Rezoning Transportation Analysis

Petition Number: 2020-067

General Location Identifier: Tax ID 09505544

Date	Description
05-18-20	First Review

RZ-2

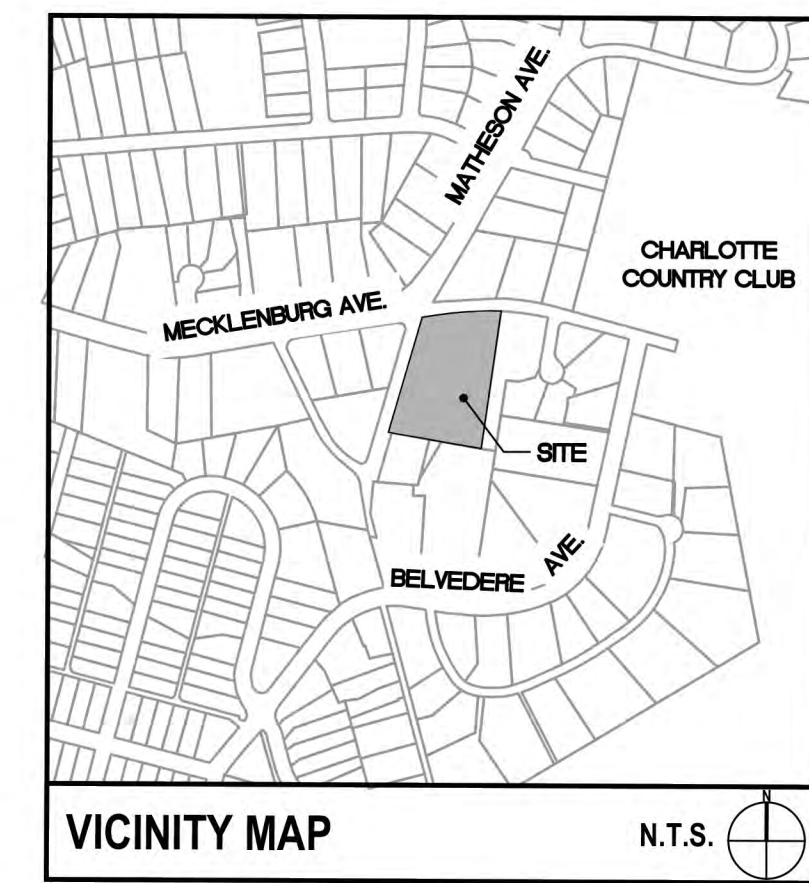
- Curblines** The proposed zoning district has a setback measured from back of the existing or proposed future curblines.
 - Mecklenburg Avenue (Spell it out):** The existing back of curb and gutter should be relocated 17.5' from the centerline.

The site plan should show the curb and gutter labeled and dimensioned from the centerline for each road.
- Traffic Study** A Traffic Impact Study is not necessary for the complete review of this petition. If during the permitting process the site generates more than 2500 daily trips, then a traffic study will be required.
- The petitioner should revise the site plan and conditional note(s) to commit to constructing an 8-foot planting strip and a 6-foot sidewalk on Mecklenburg Avenue per Chapter 20 Subdivision. The site plan should label and dimension both items from the back of curb and gutter and road centerline.

- The petitioner should revise the site plan and conditional note(s) to commit to constructing a public street, Matheson Avenue south of Mecklenburg Avenue, as a Local Residential Medium with an 8-foot planting strip, and 6-foot sidewalk per Chapter 20 Subdivision ordinance.

5. The petitioner should revise the site plan to add a note specifying dedication and fee simple conveyance of all rights of way to the City before the site's first building certificate of occupancy is issued. CDOT requests right of way set at 2' behind back of sidewalk where feasible.
6. The petitioner should revise the site plan to add a note specifying all transportation improvements will be approved and constructed before the site's first building certificate of occupancy is issued. The petitioner may phase transportation improvements if said improvements and phasing are explicitly described in site plan notes.
7. ~~Resolved-Sample format for comment that is resolved~~

RZ-3

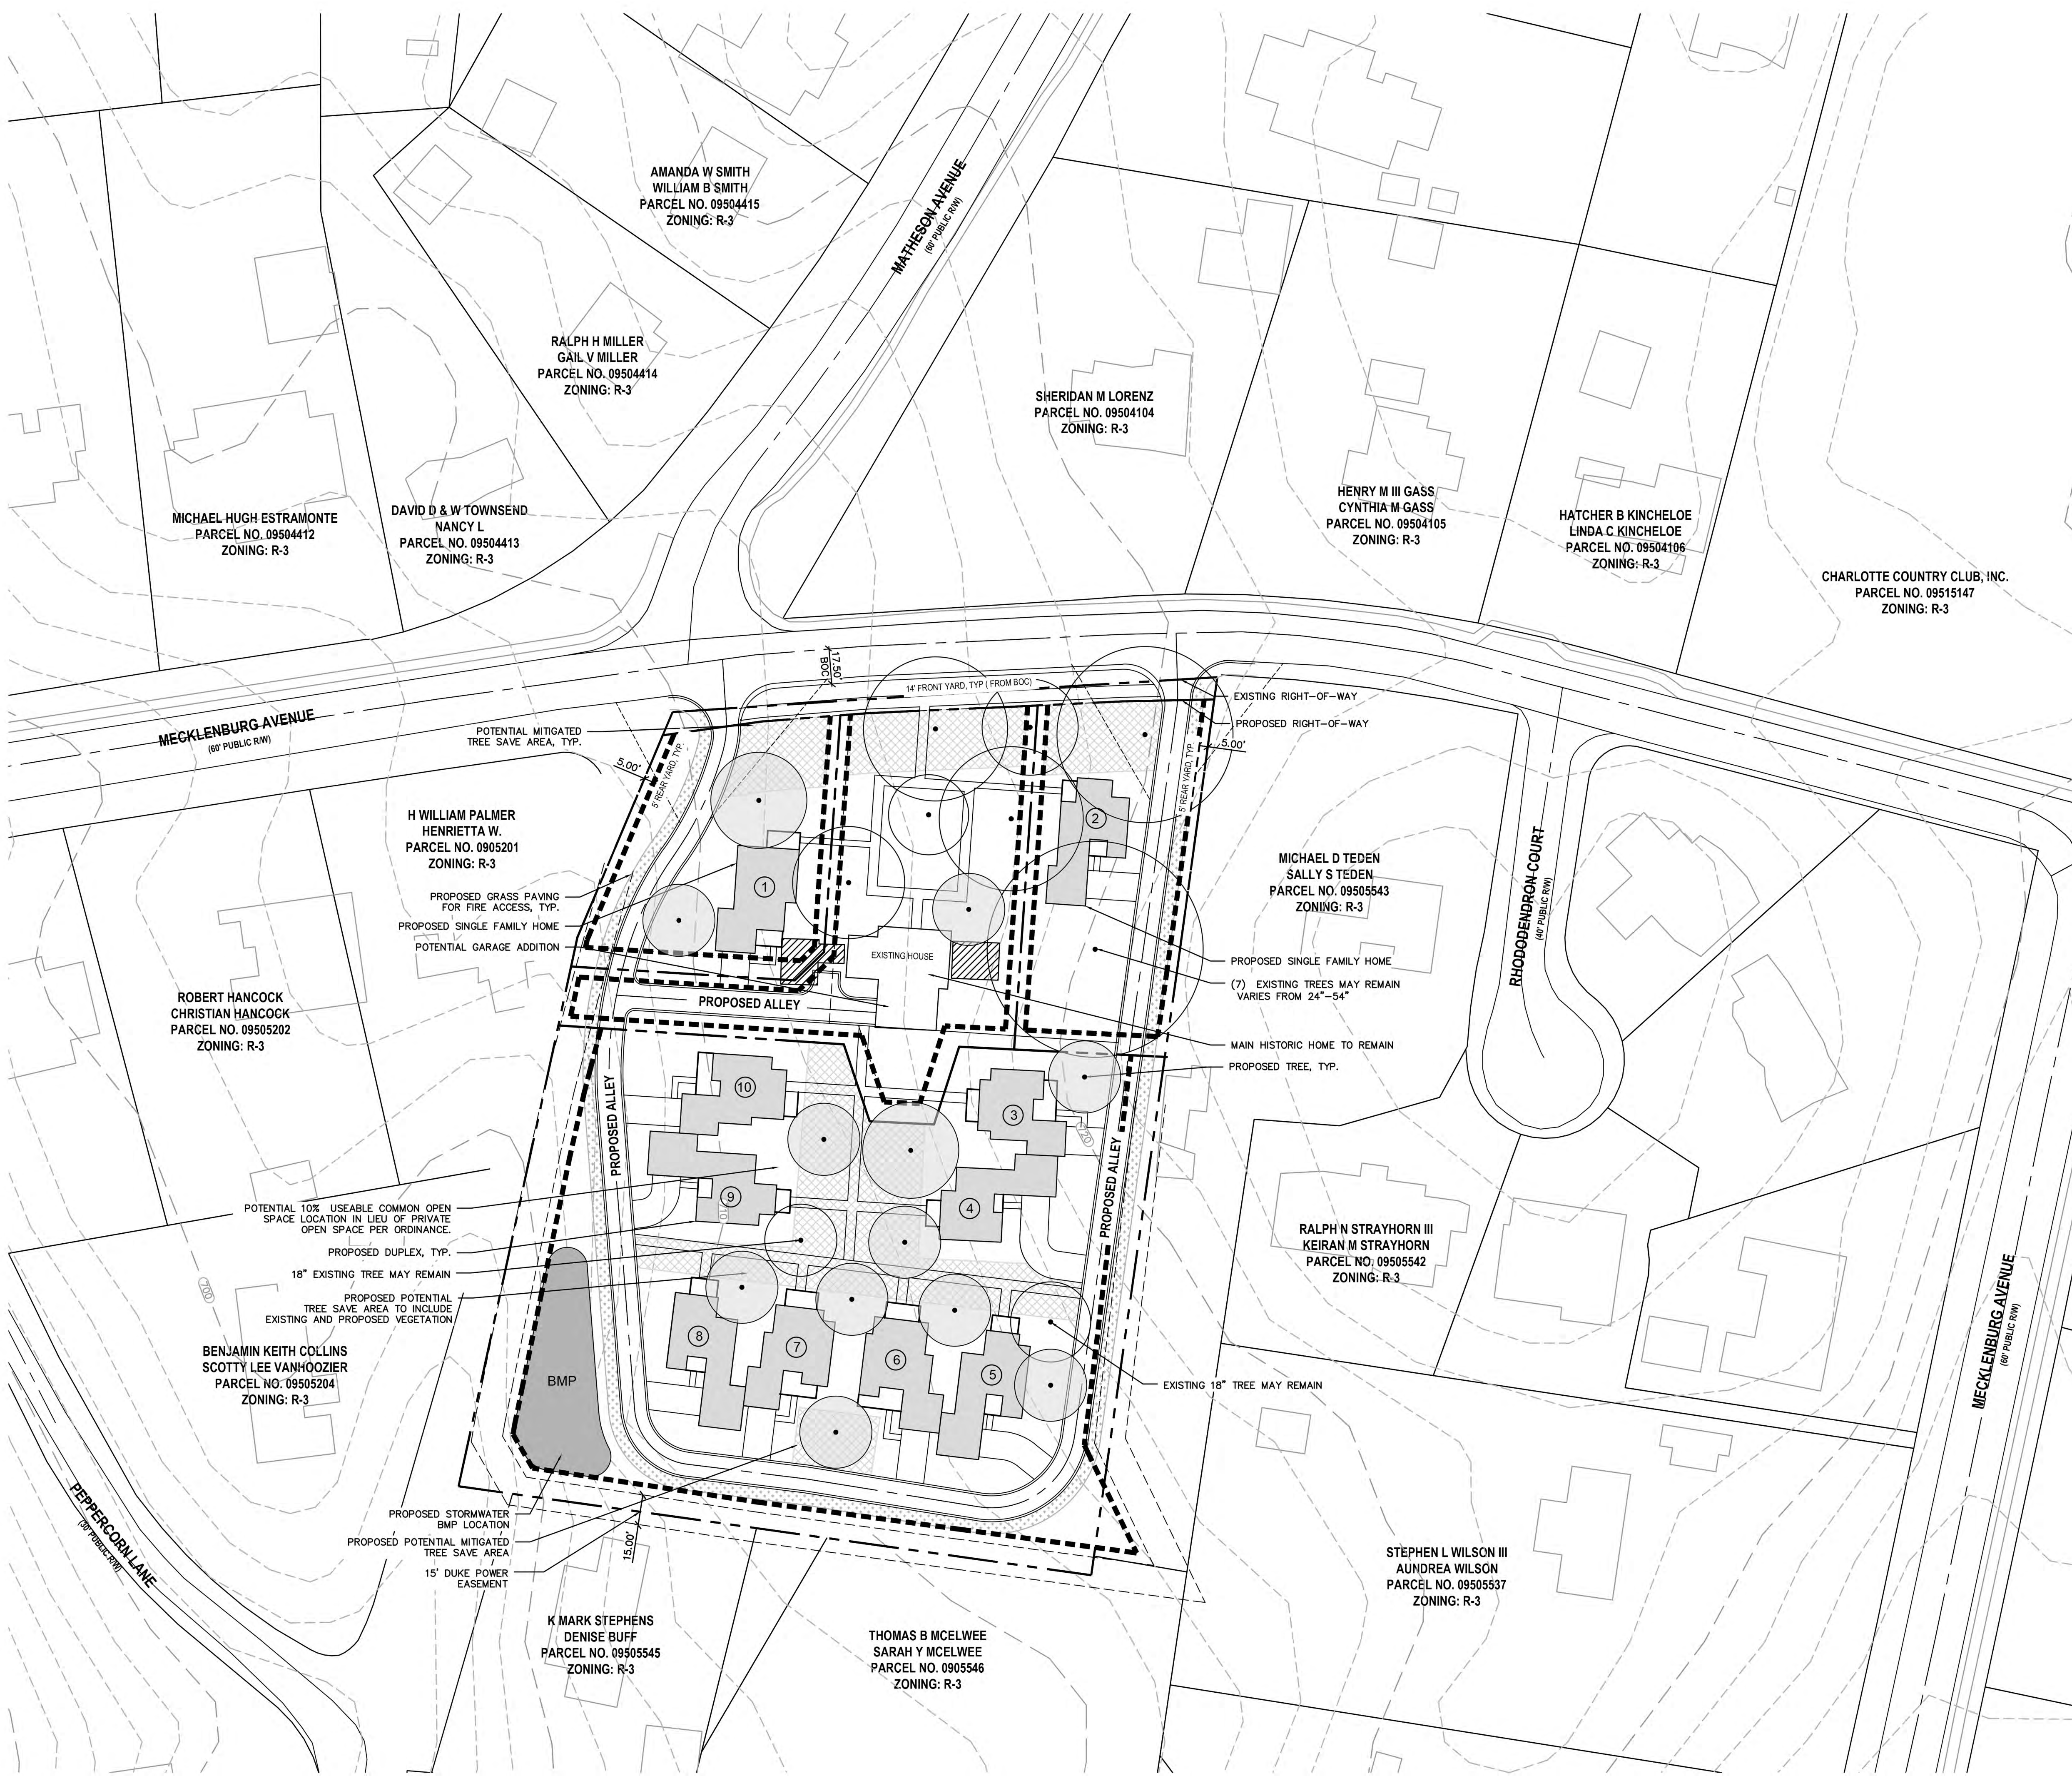
Reference (CLDSM standard detail U-03A) for street typical.
